Your Ref: FP/171/18/PL

Our Ref: NW/ARU/18/13A

RE:- Land at Stanhorn Grove Felpham

Thank you for your correspondence of 27th July 2018, advising me of the Erection of 18 No dwellings, creation of new access, landscaping & associated works application for which you seek advice from a crime prevention viewpoint.

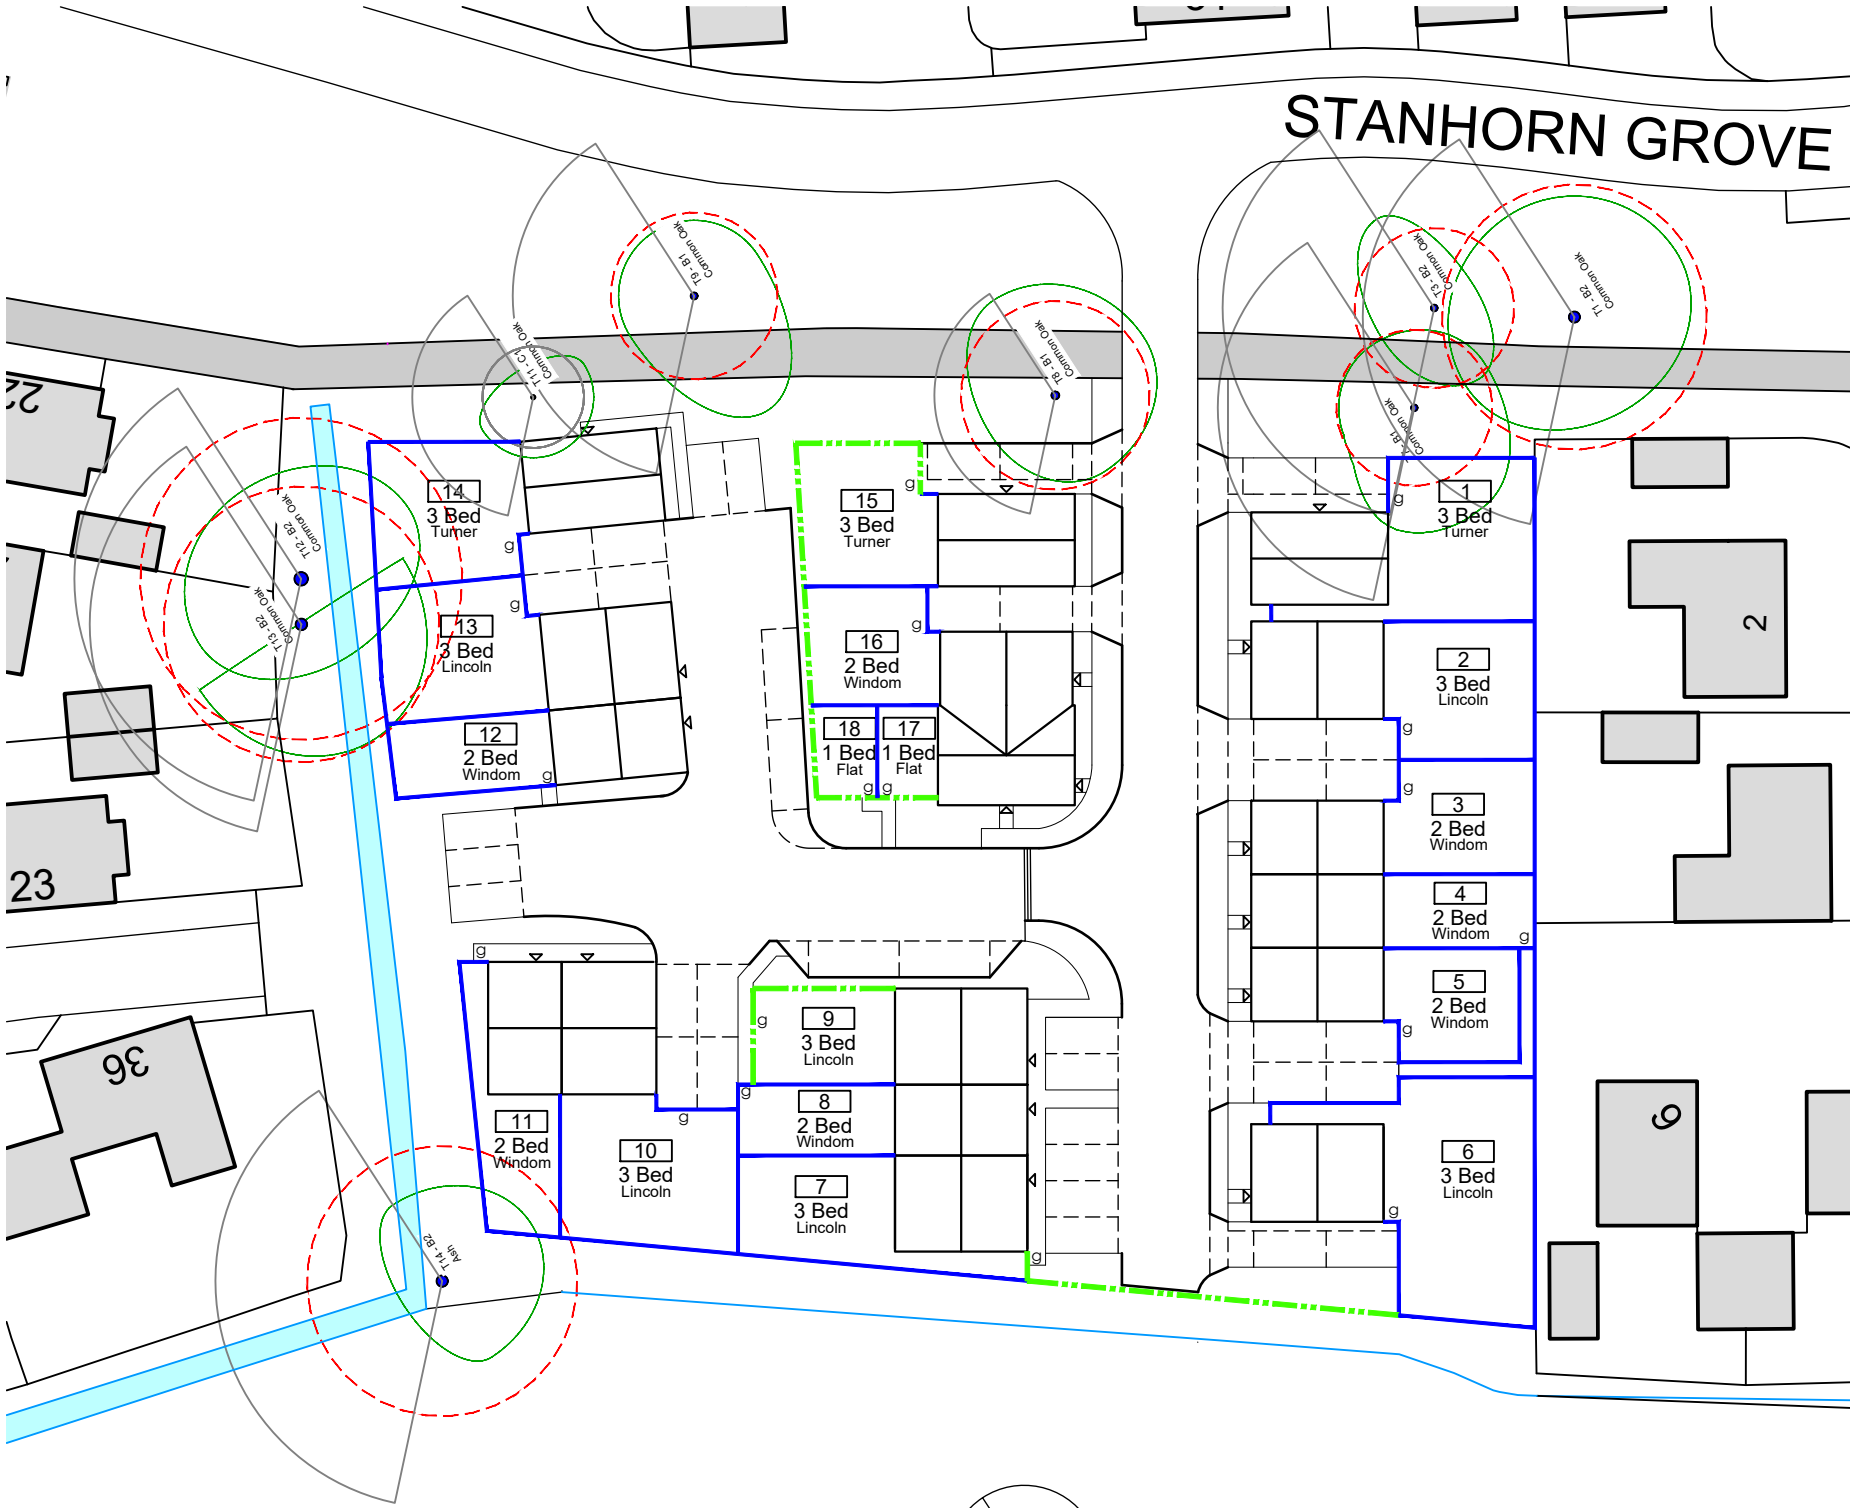
I am pleased to see that the application has provided 1.8m high close boarded fencing or low level walls with piers and close boarded 1.8m high wooden fencing between.

I would recommend that wooden close boarded fencing over the low walls and between the brick piers is fitted toward the outer edge of the wall to prevent footholds on the external side which could enable climbing.
